CITY OF ALBUQUERQUE

**Planning Department
Transportation Development Services Section**

Re: **Certification for Permanent Building Certificate of Occupancy (C.O.)**
Lowes Parcels (Los Angeles Center, Tract A-1B-1-B & A-1-B-1-C), [D-18/D014D]
6230 Paseo del Norte
Architect's Stamp Dated 01/10/13

RE: Los Angeles Center (Lowes' out-parcels), Tracts A-1-B-1-B & A-1-B-1-C
Grading and Drainage Plan for Grading, Paving and Building Permit
SW Corner of Paseo del Norte & San Pedro PE Stamp: 7/11/12 (D18-D014D)

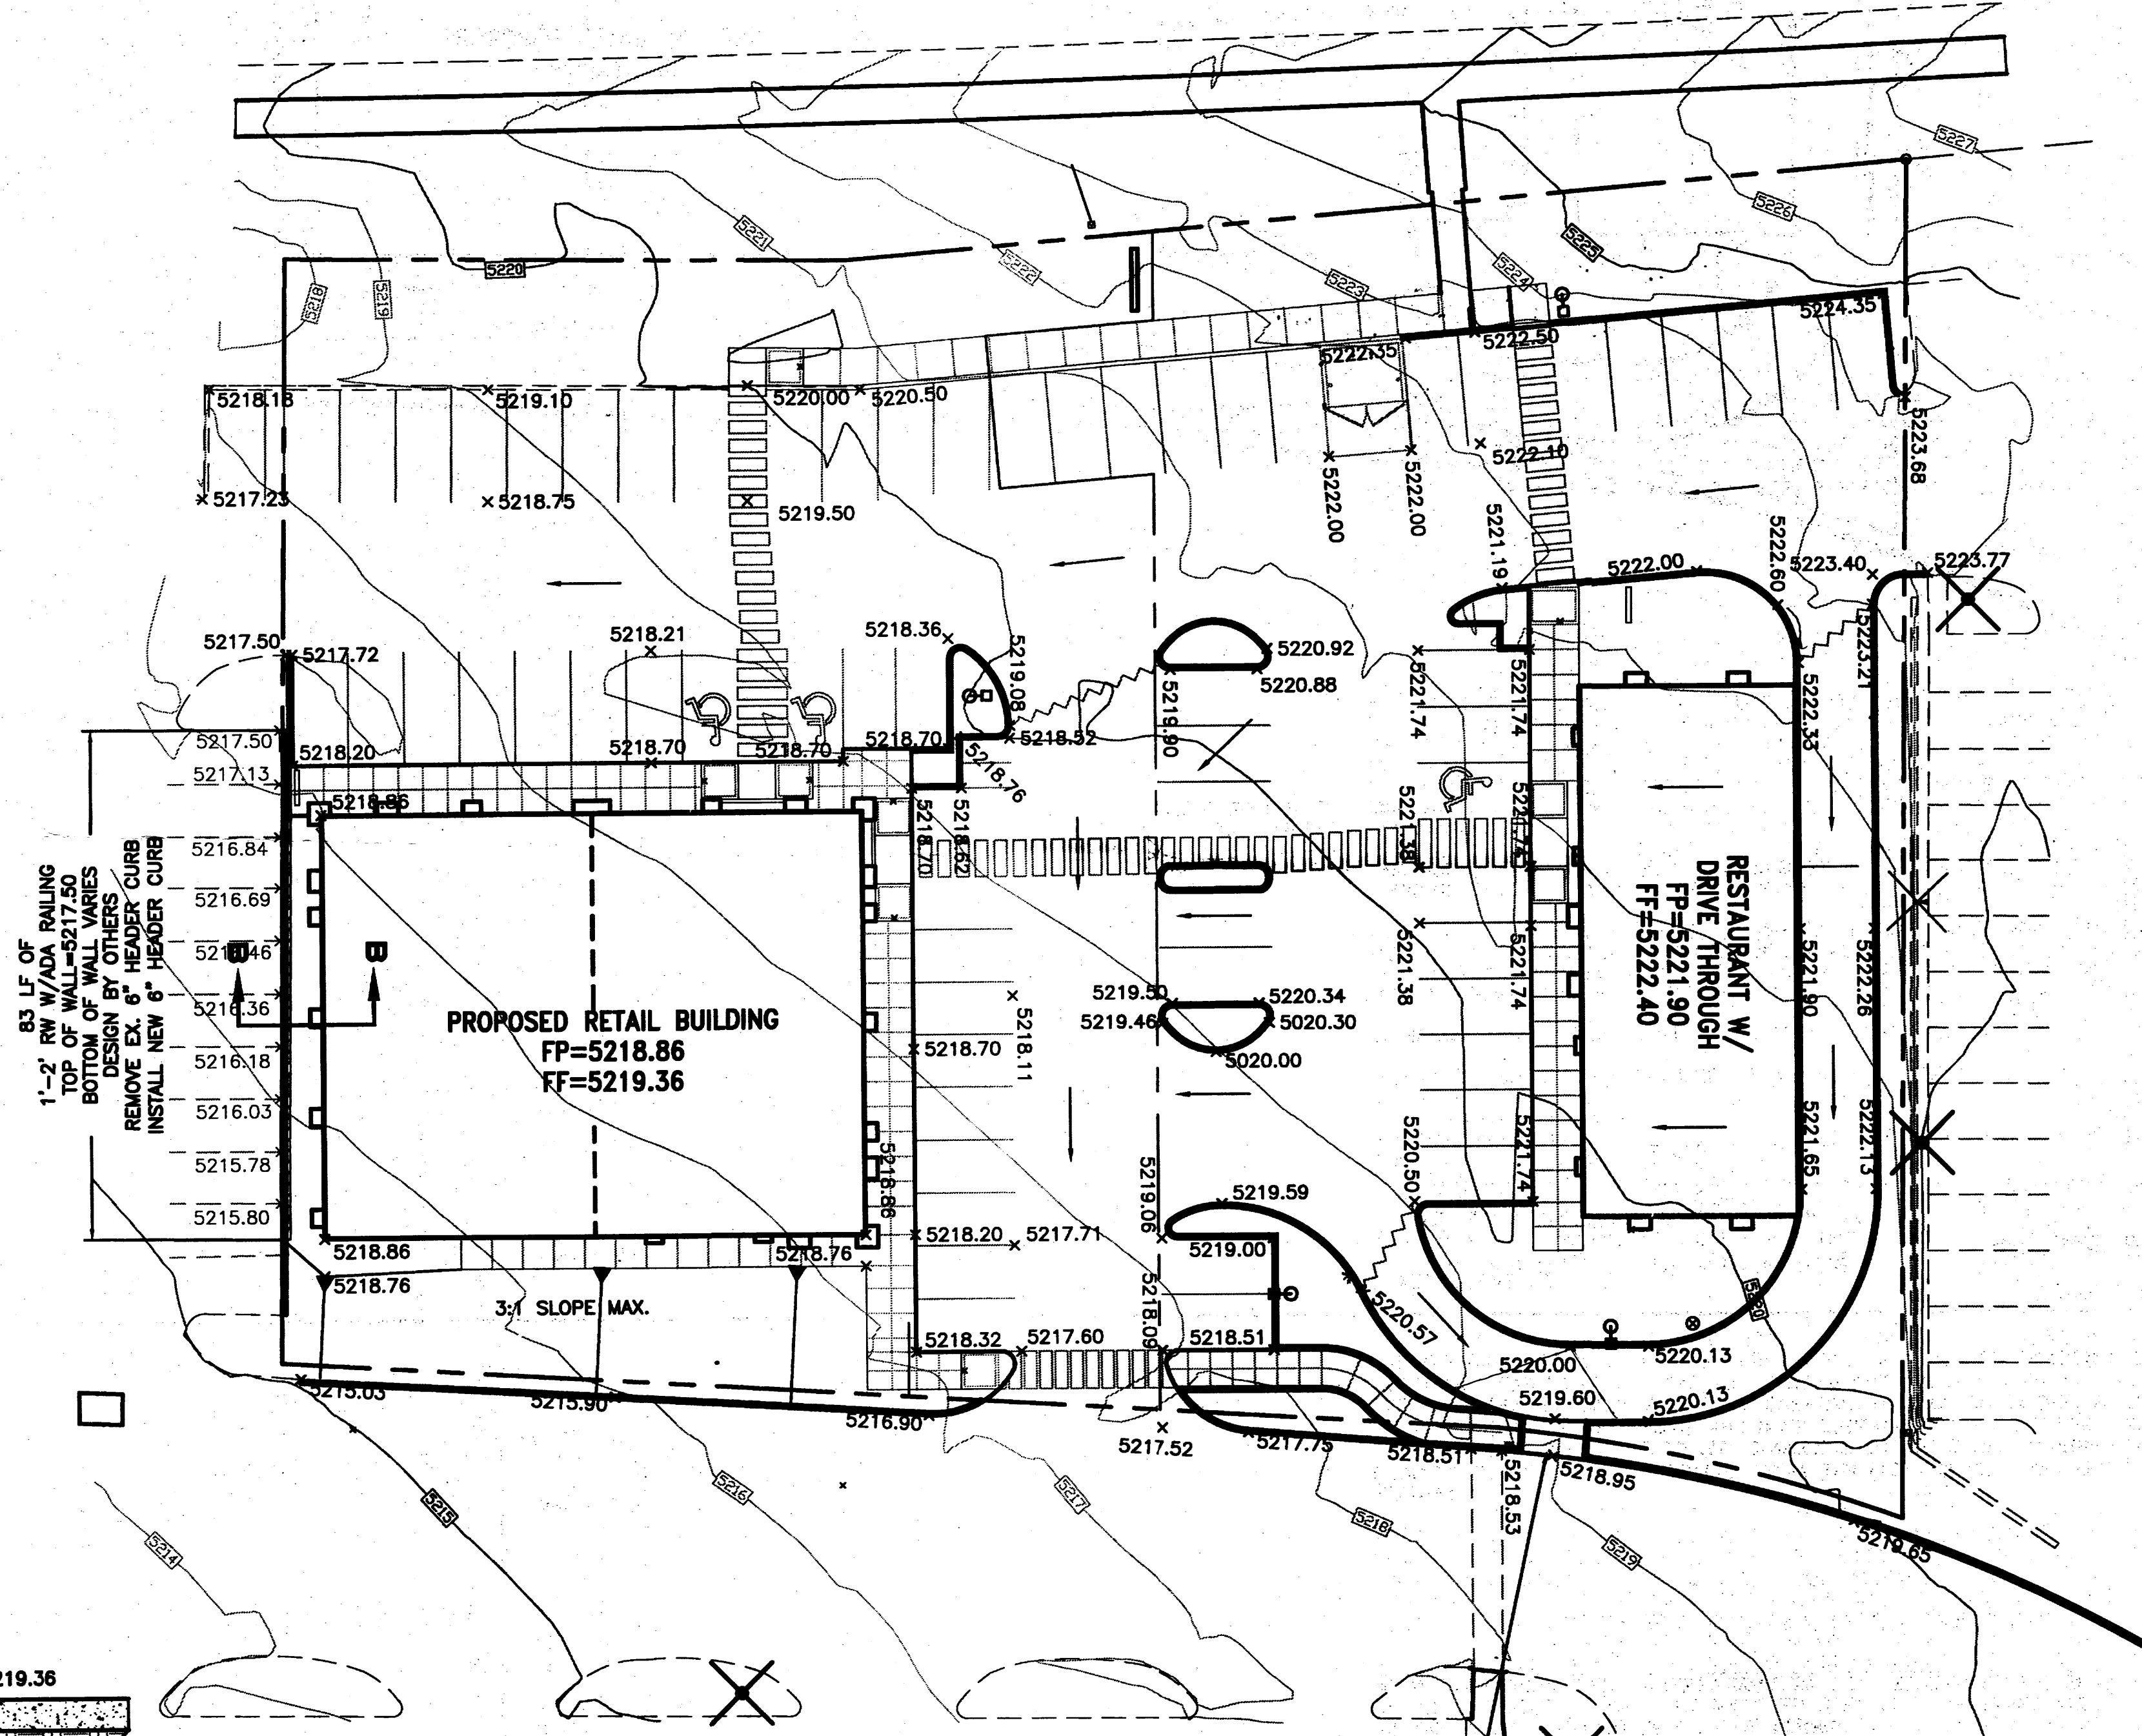
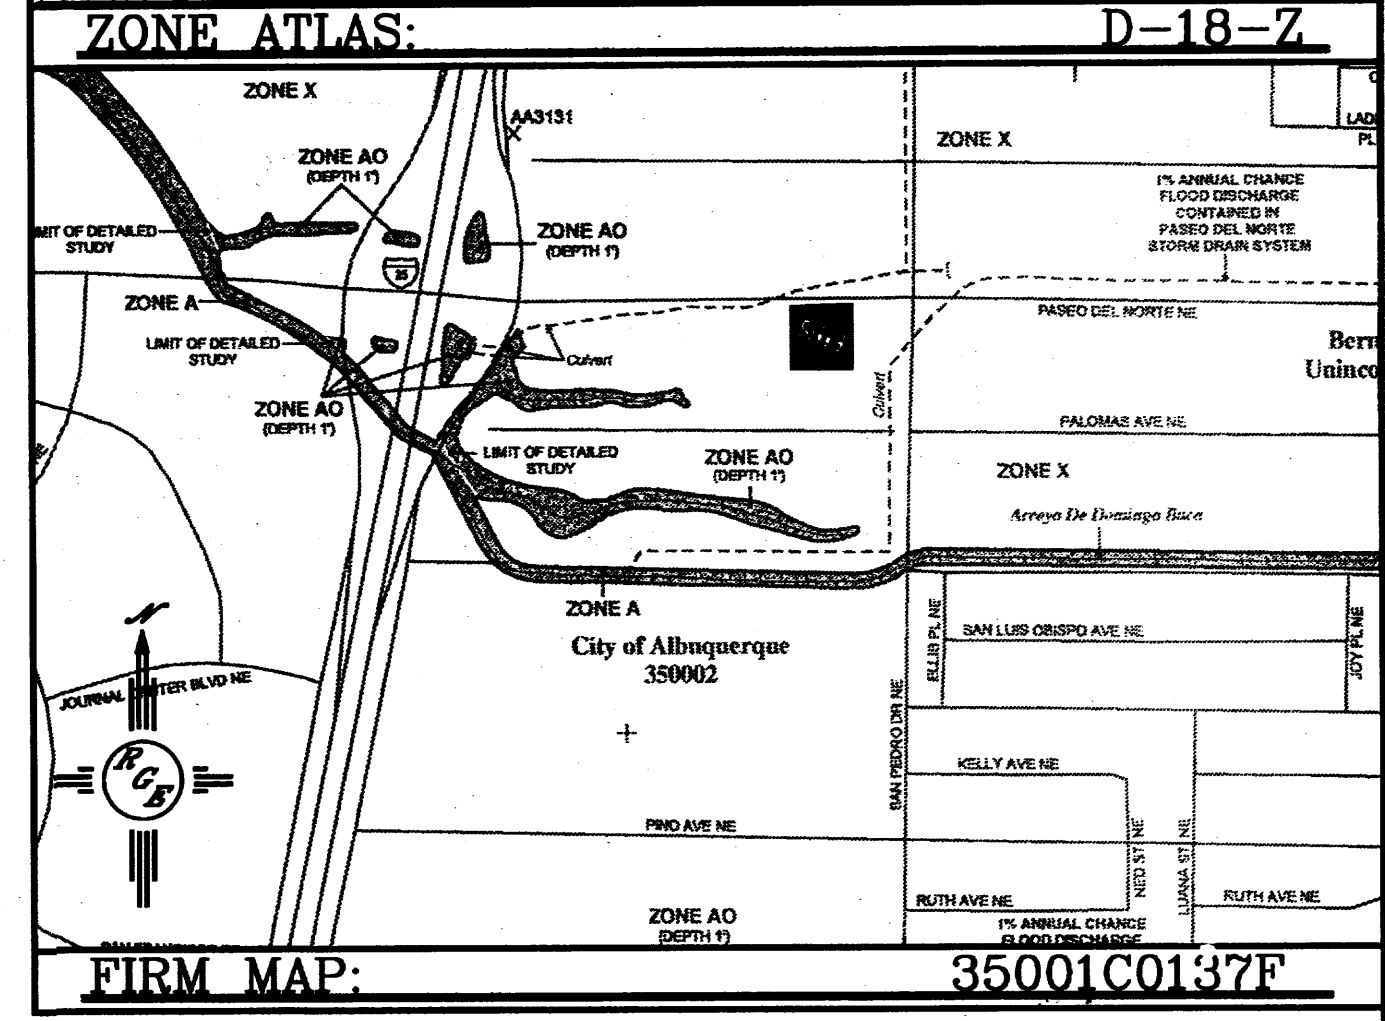
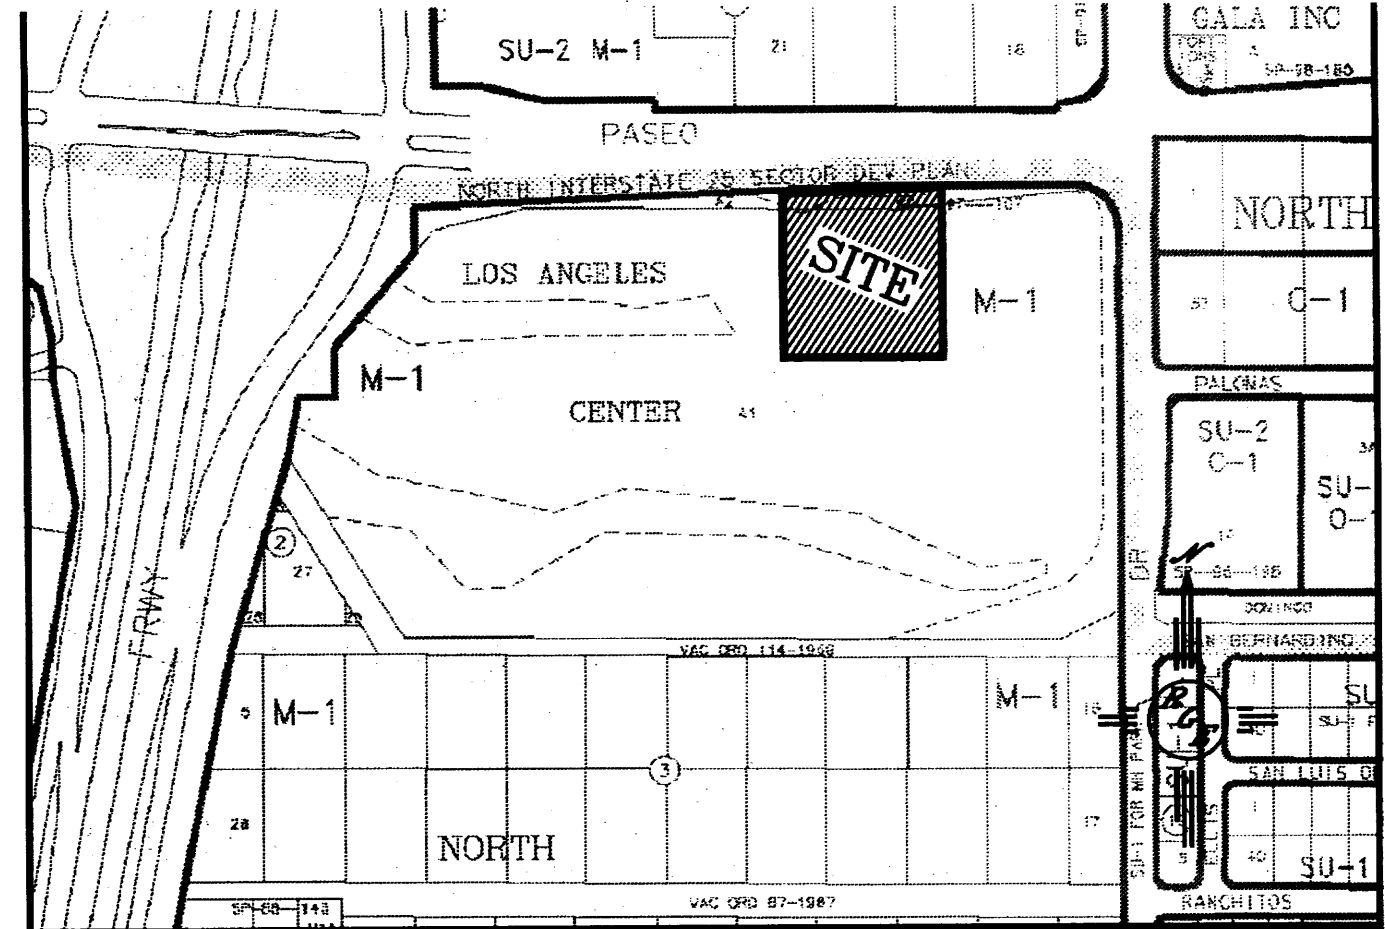
Sent: Friday, June 29, 2012 1:31 PM

Here are some quick notes on the items I flagged in your Grading & Drainage submittal signed 5/18/12.

1. **Where does roof runoff go from SW building?** Avoid erosion on the steep side slopes S & W of pad. - added a cobble swale and place note that roof drains shall connect to cobble swale on west side. south side has no roof flow but added note for larger angular rock landscaping.

2. Per DPM, the Dumpster pad for the restaurant must drain to the Sanitary Sewer.
Show this on the plan. -please add to both utility and grading

3. At the 10' rundown south of the restaurant:

a. at 10' wide will it become a shortcut to the drive-through? - put bollard in middle

b. The original Lowes site had a N-S pedestrian corridor just west of the restaurant pad.
This plan seems to carry that through the site, except at the drive-through.

Will it be continuous, and will it be **compatible with the drainage rundown?** sidewalk turns to south at existing cross walk. There was a bid deal about carrying cross walk across drive thru, the was worked out by architect and transportation. I agree, the initial layout didnt have this but the drivethru traffic forced layout.
